NORTH FALLS OFFSHORE WIND FARM

**Appendix C5 to the Natural England Deadline 5 Submission**  
**Natural England's Benthic Ecology Advice on the Applicant's Deadline 4 Documents**

Planning Inspectorate Reference EN010119

30 May 2025

**Figure 4.1 Predicted percentage change in current speeds due to the Project during peak flood of spring tide (positive indicates an increase in current speed and negative indicates a decrease in current speed)**

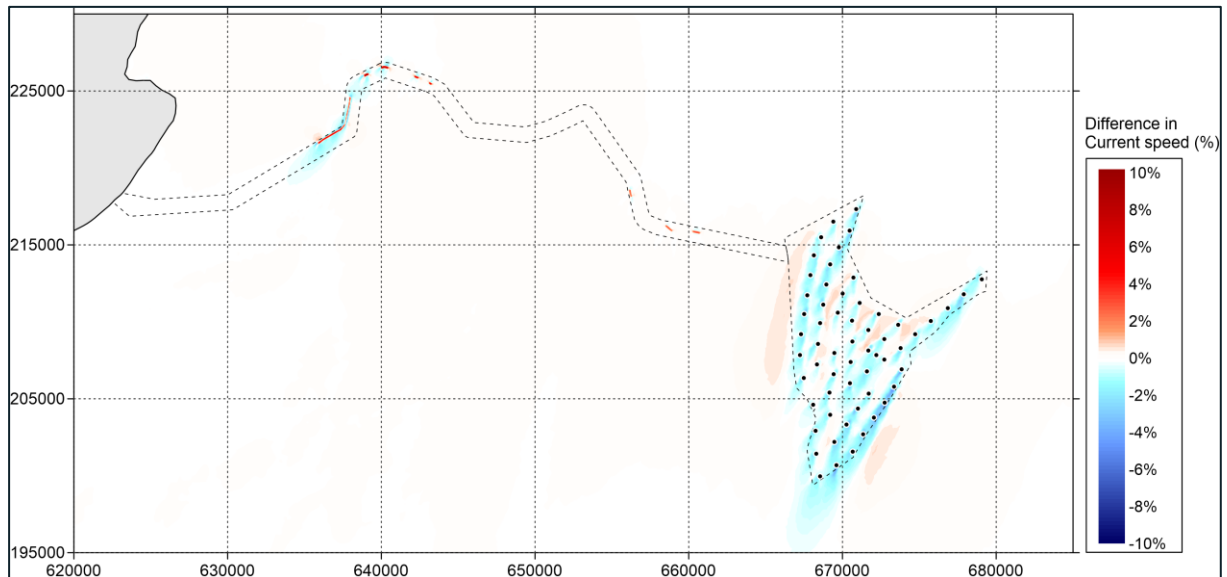
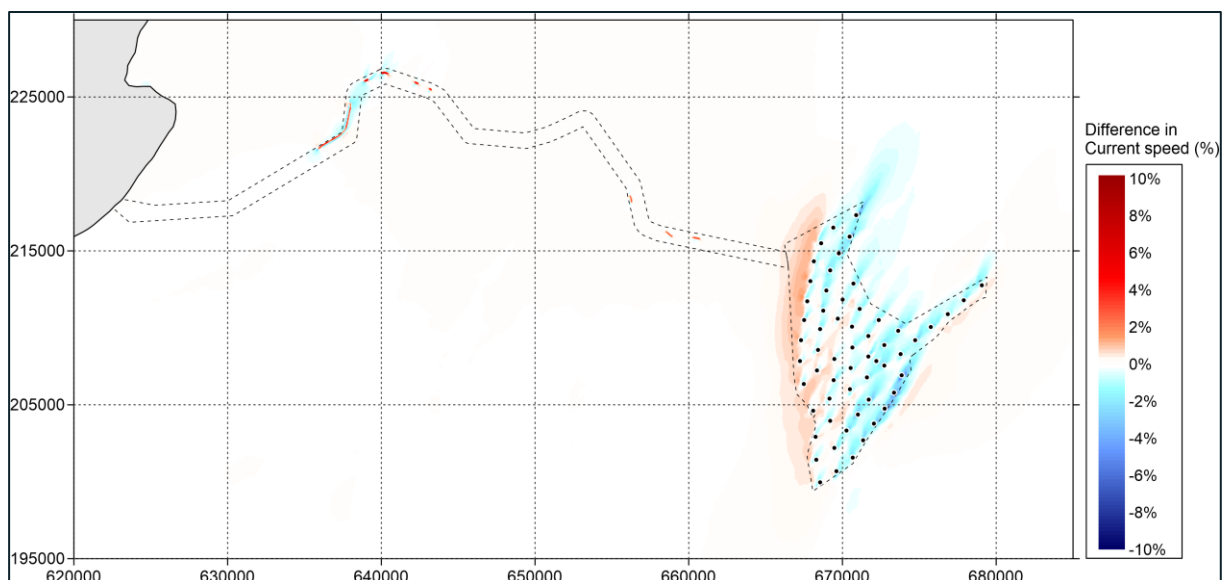
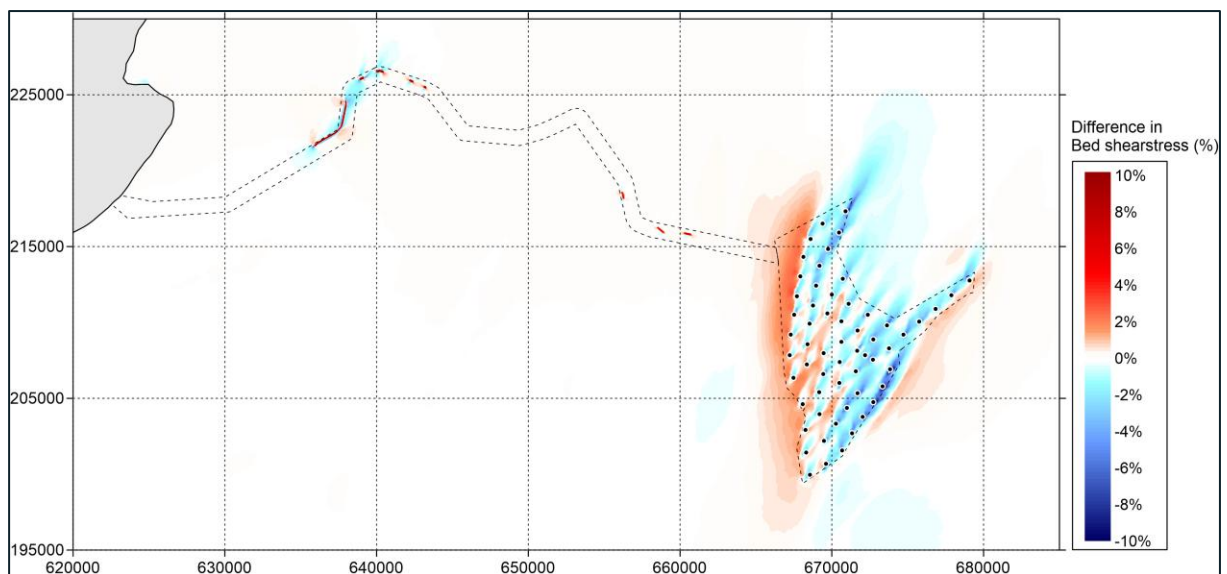
NE Ref	Section	Key Concern and/or Update	Natural England's Advice to Resolve Issue
1	Section 4	Natural England notes that the changes in current speeds and bed shear stresses due to the presence of turbines and/or cable protection presented in [REP4-042] have not been used to predict the morphological changes (such as scour/sediment accretion, changes in sediment character) that could alter the extent, distribution	Natural England advises that further interpretation of the hydrodynamic modelling is required to provide a robust and transparent understanding of likely WCS impacts on benthic ecological receptors from changes in supporting processes within Margate and Long Sands SAC and Kentish Knock east MCZ.

and composition of benthic communities within the adjacent designated sites during the operational phase. It is not therefore possible to determine the likely nature and/or extent of these secondary pathways of effect or determine whether they may extend into Margate and Long Sands SAC and/or Kentish Knock East MCZ.	In the absence of this information, it is not possible to determine the likelihood of an AEol and/ or hindrance of the conservation objectives of the MLS SAC and KKE MCZ respectively during the operational phase.
2	Sections 4.3.2 to 4.3.4	Natural England considers that the assessment of receptor sensitivity, impact magnitude and effect significance altogether lack consideration of ecological receptors.	Natural England advises that further interpretation of the hydrodynamic modelling is required and should be considered in the context of ecological receptors to provide a robust and transparent understanding of likely WCS impacts from changes in marine processes within Margate and Long Sands SAC and Kentish Knock east MCZ.
